## **Notes on County Comments**

Mountain States Pipe and Supply Replat  
2021/03/08

AS REPLATTED

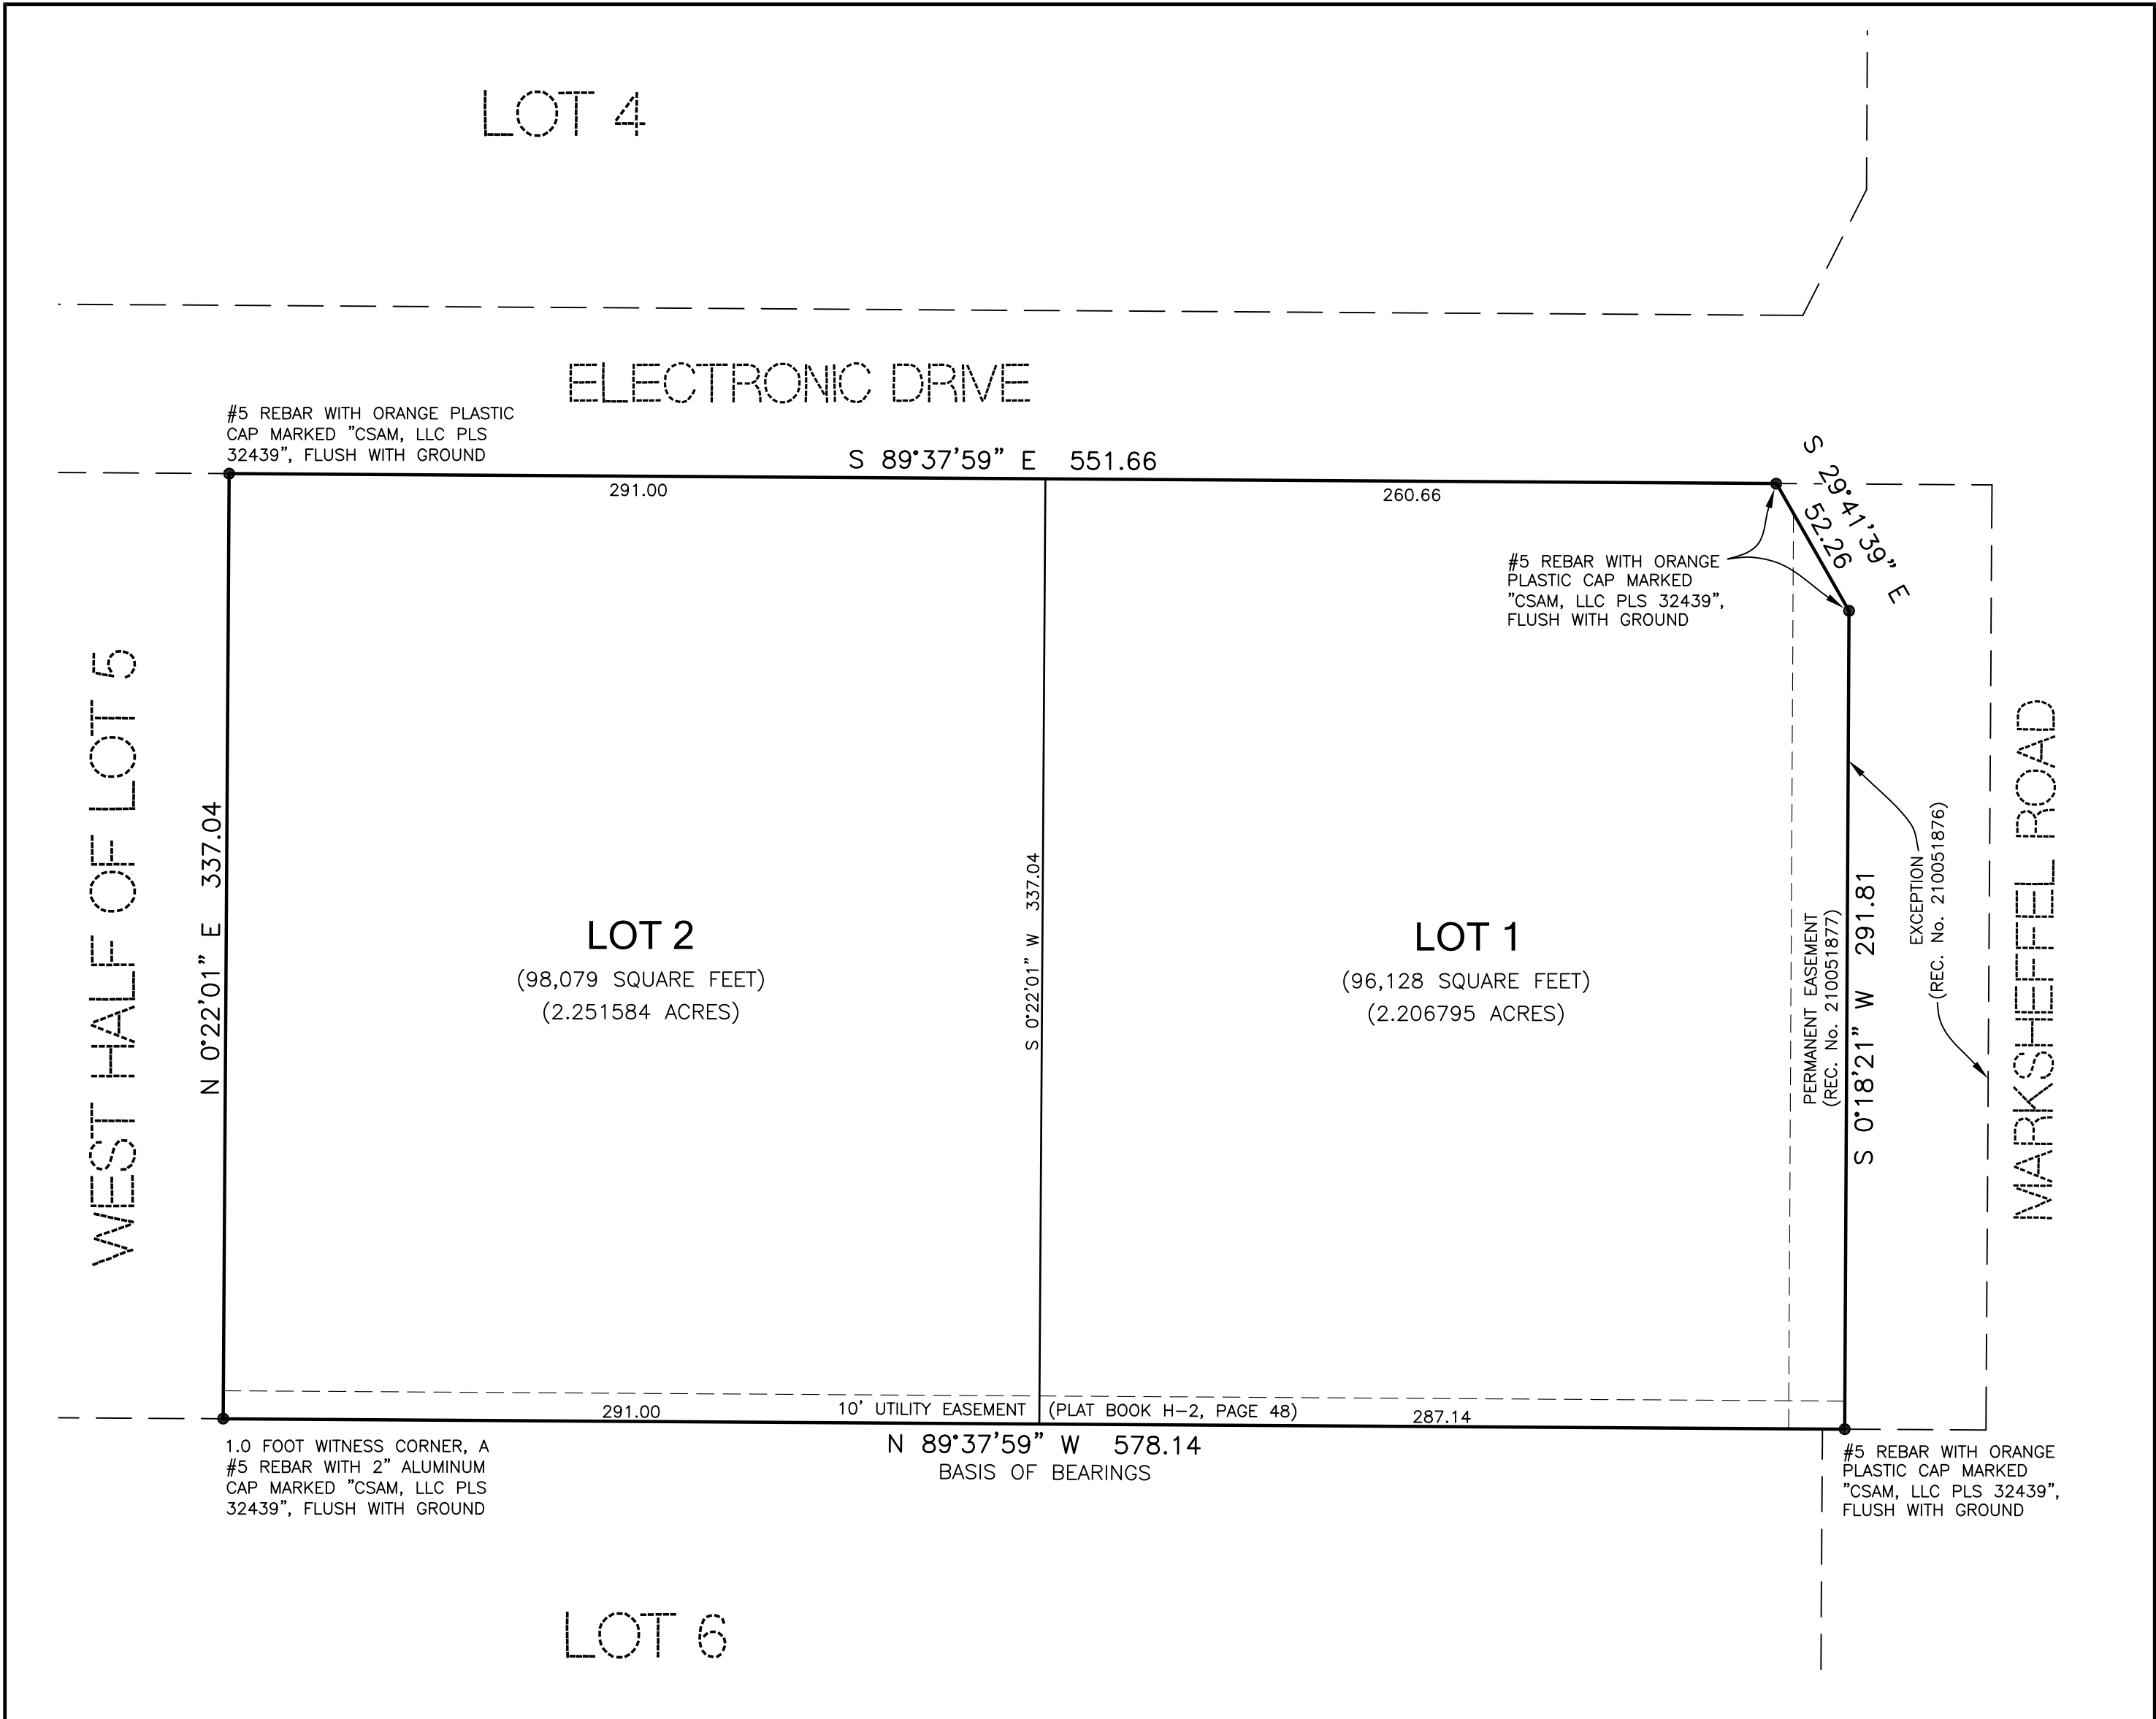
"C: Plat - Per comments provided on EDARP through email by the drainage engineer it appears that access to lot 2 will be provided from the existing access from lot 1. If so then please provide a joint access easement on the plat and provide a maintenance agreement. If not then comment from review #3 above will apply.

Q: Lot 2 access is proposed through Lot 1. The easement and maintenance documents have already been submitted with the development plan. Do you just want those documents submitted with the plat as well? As I understand it (not the surveyor), the access easement is being created before the plat is recorded (separate instrument). Do you want the easement created in a different way?"

Plat Comment: The joint access documents have previously been submitted as part of the Electronic Storage DP. The questions below were sent to the County on 2021/02/19, and no answers were received. Therefore, it is assumed the joint access documents submitted with the DP are acceptable, and they have been included with the resubmittal.
